Your Ref: 000014143
Our Ref: A/112/12/ 01-11-2012
Please ask for:
Mr P Cleveland

Rear decking and fencing to form outside seating area
Lamb Inn The Square Angmering Littlehampton

A/112/12 Lamb Inn Rear Decking and Fencing to form outside seating area

EXISTING REAR CAR PARK & PROPOSED NEW EXTERNAL SEATING AREA

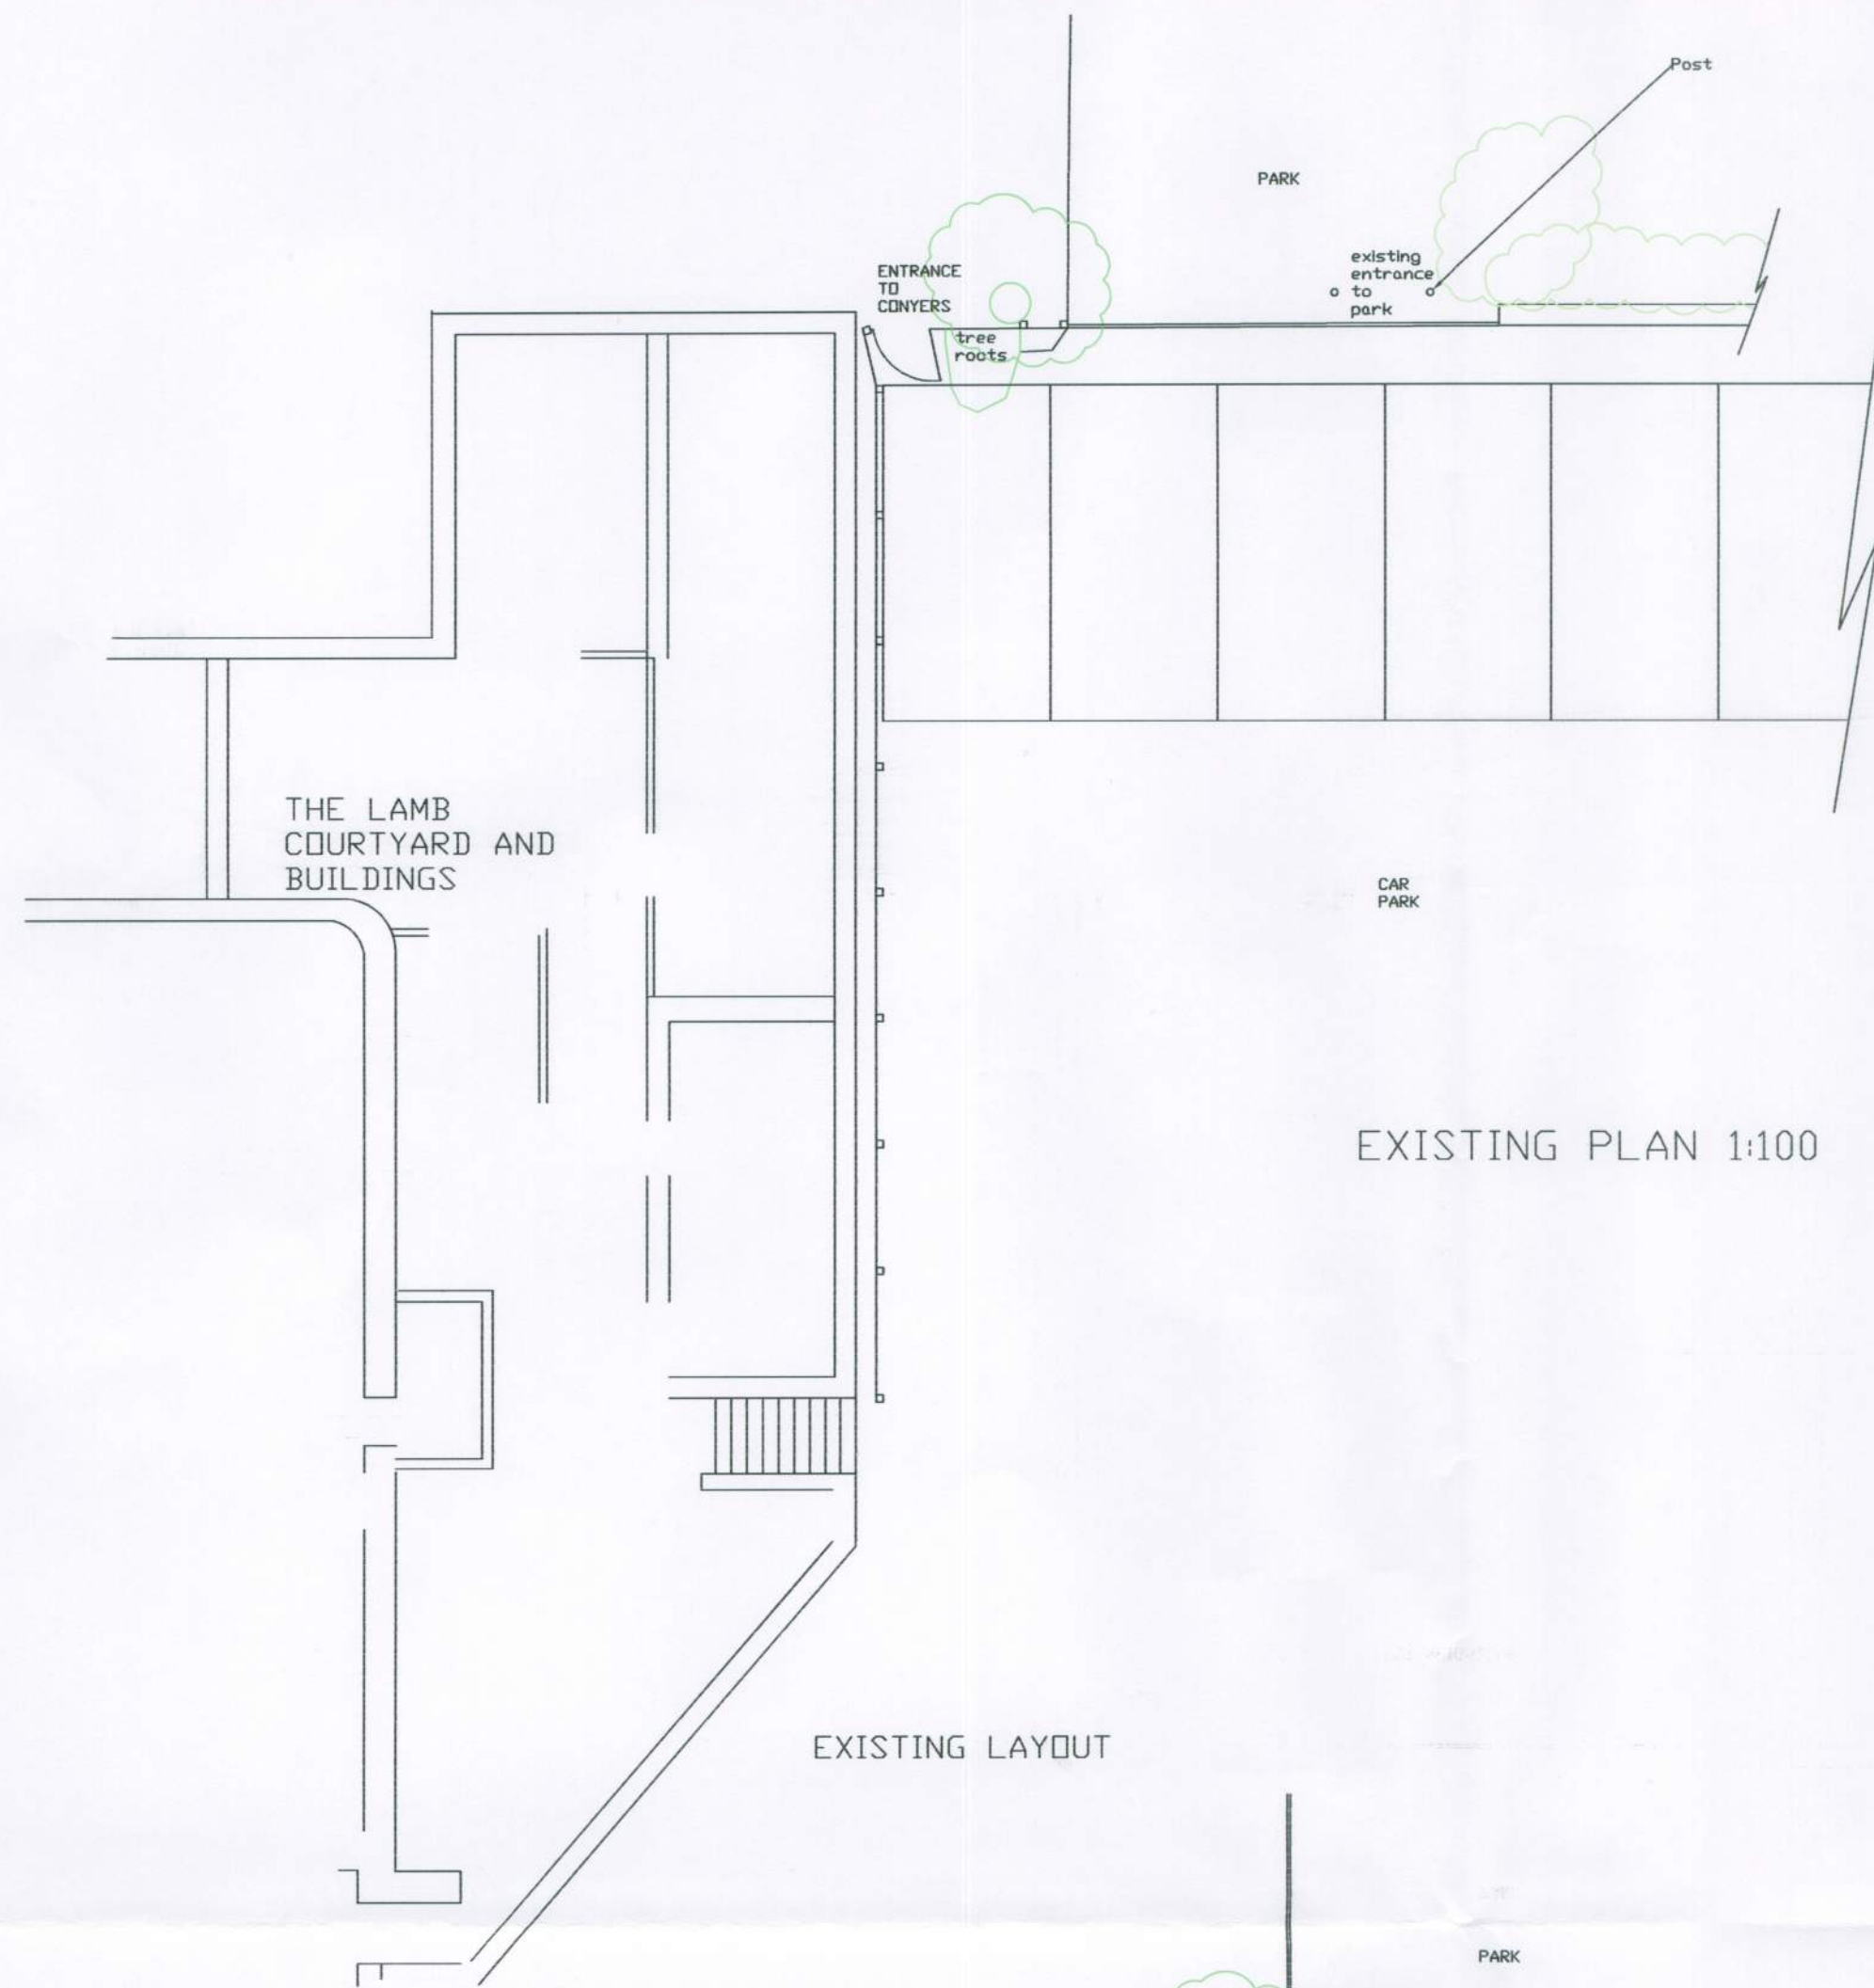
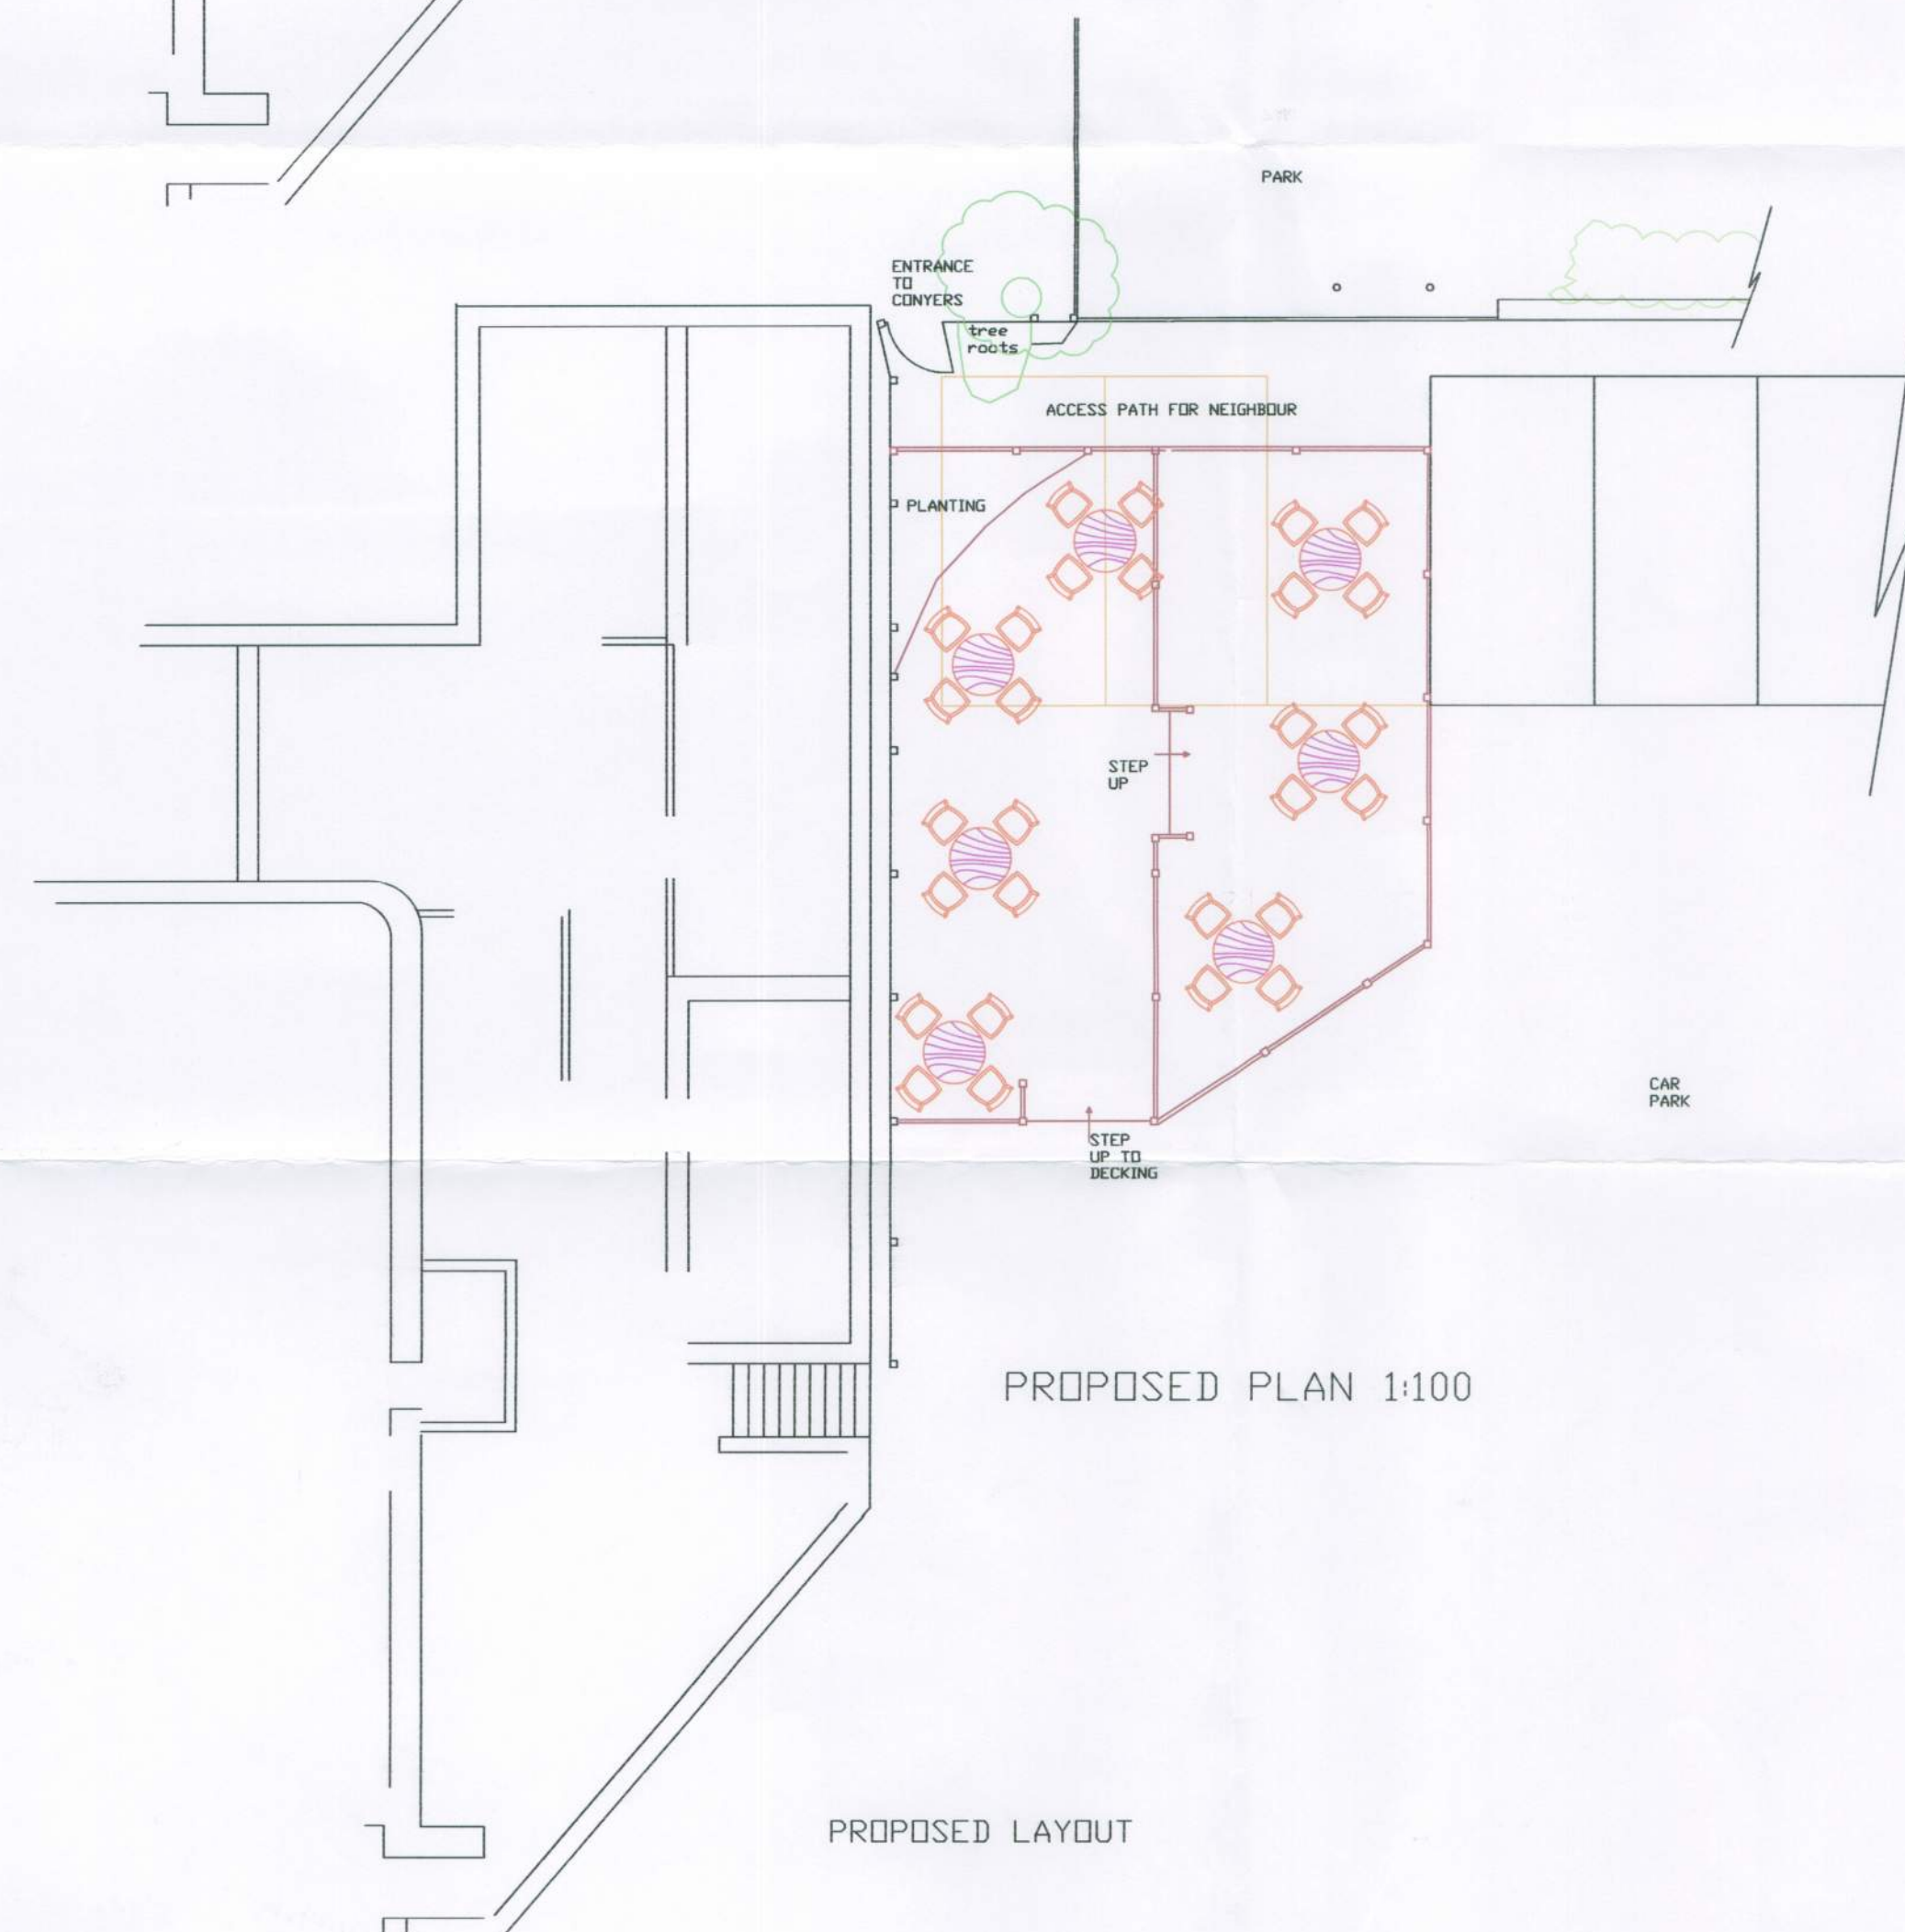
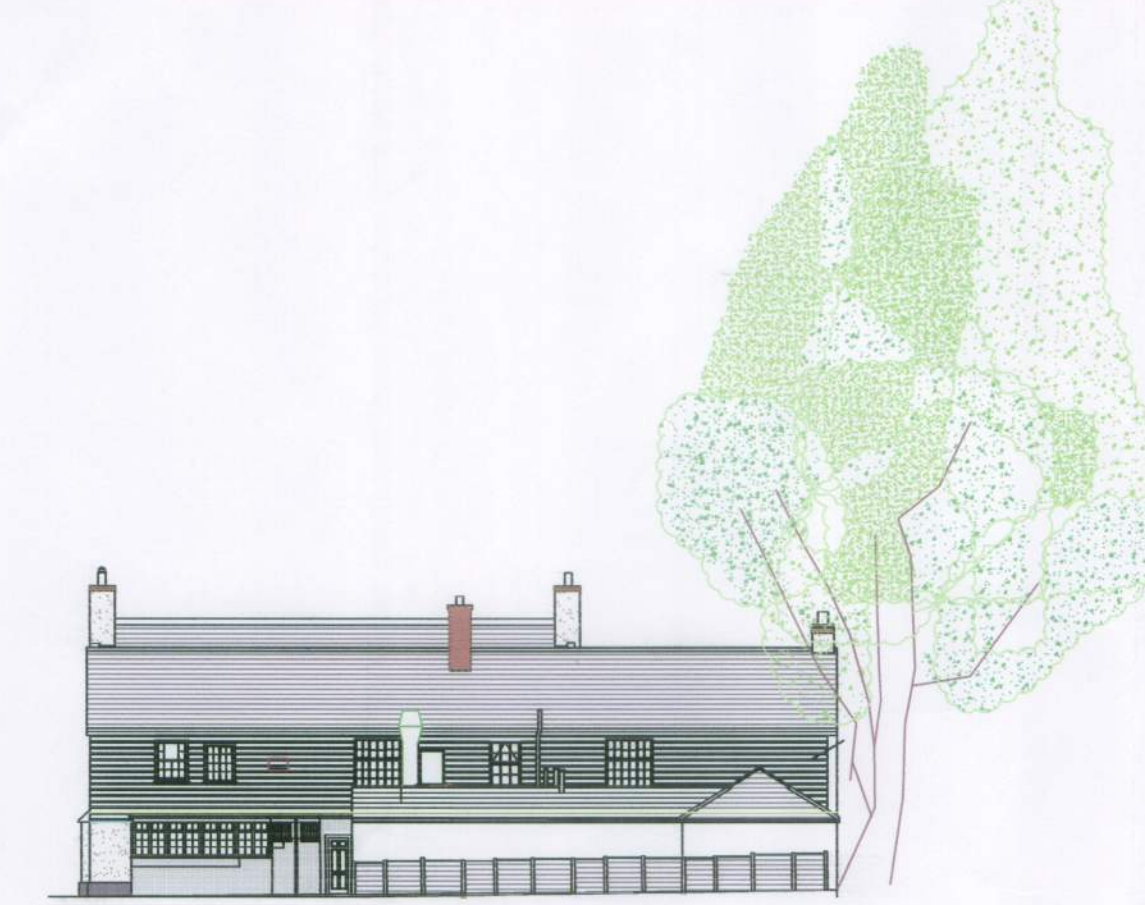
The Applicant refers to the access to the park as being an informal arrangement and I note (with concern) that the Statement (02/11/2012) that was submitted with the application and which referred to the proposed relocation of the existing entrance to the park to slightly west of the proposed decking has been superceded by a Statement (30/11/2012) that makes no mention of such a relocation, and by inference intends to deny access in the future. In fact, the plans indicate that fence screening would block the existing access.

- 1. The present owners are owners of not more than three years*
- 2. The public has had unrestricted access to St Nicholas Garden across the car park for at least the last 20 years*
- 3. The car park access is the only adequate access for the proper maintenance and repair of the garden, not least for the 'sit on' mowers that are essential for the grass cutting.*
